November 16, 2022

Re: PA22-042 – Sunnyside Village Co-Housing – Technical Review 1
3121 66th Ave NE – APN: 29050300402100

After preliminary review of the above referenced proposal, the Planning Division has the following comment(s):

# G210

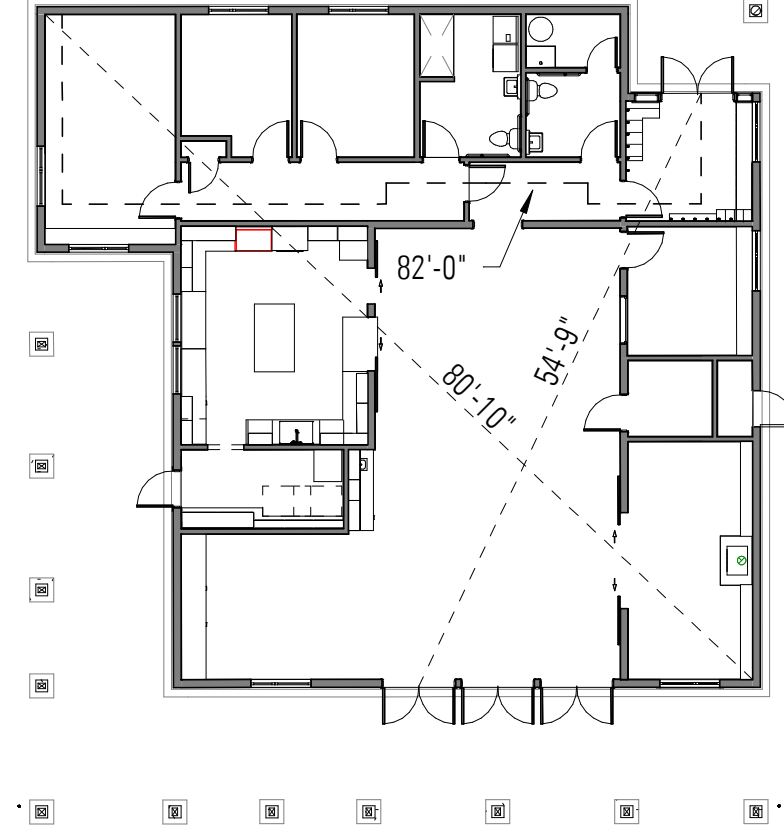
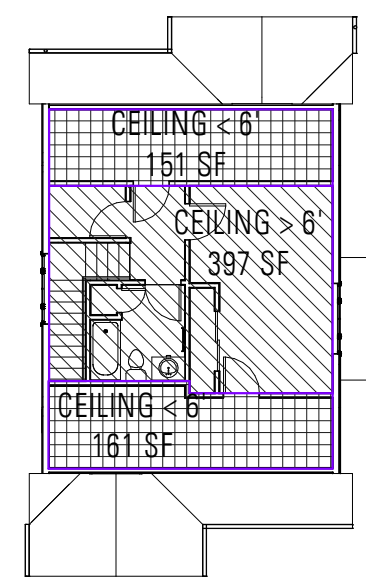
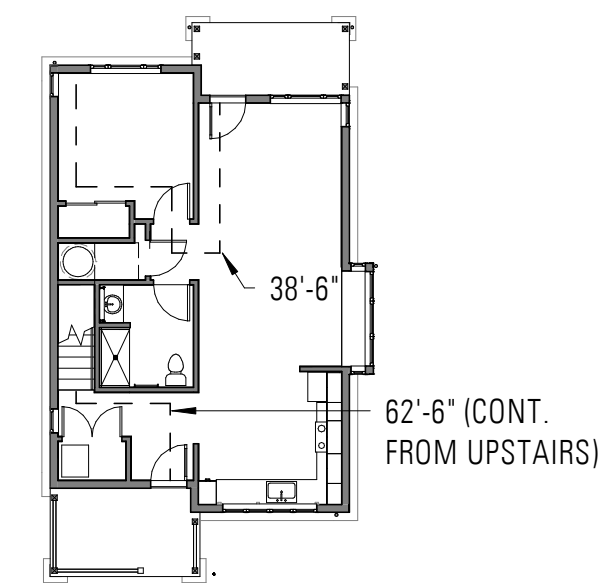
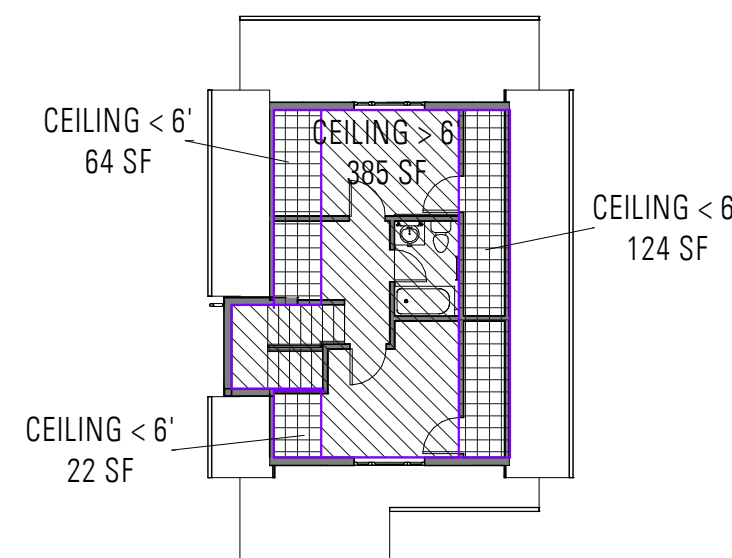
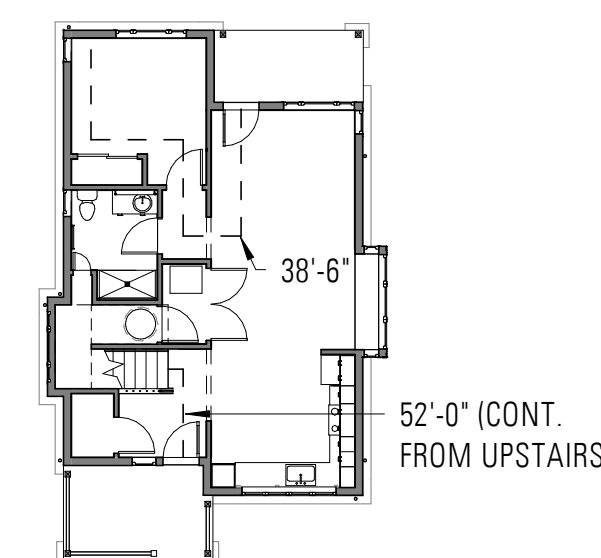
4. Preliminary cottage floor plans are needed to ensure compliance with the following dimensional standards of MMC 22C.010.280(7):
 - 4.1. Maximum cottage main floor area: 800 sq. ft.

- 4.2. Maximum cottage total floor area: 1 ½ times the area of the main floor or 1,200 sq. ft. (whichever is less)
 - 4.3. Primary Porch: 60 sq. ft. with min. dimension of 6 ft.

- 4.4. Secondary Porch: 36 sq. ft. with min. dimension of 6 ft.
5. Staff has reviewed the requested modifications and variances proposed per MMC 22C.010.280(14) and has the following comments:

4 - SW: Sheet G210 has been included in resubmittal documents, and demonstrates compliance with referenced dimensional standards.
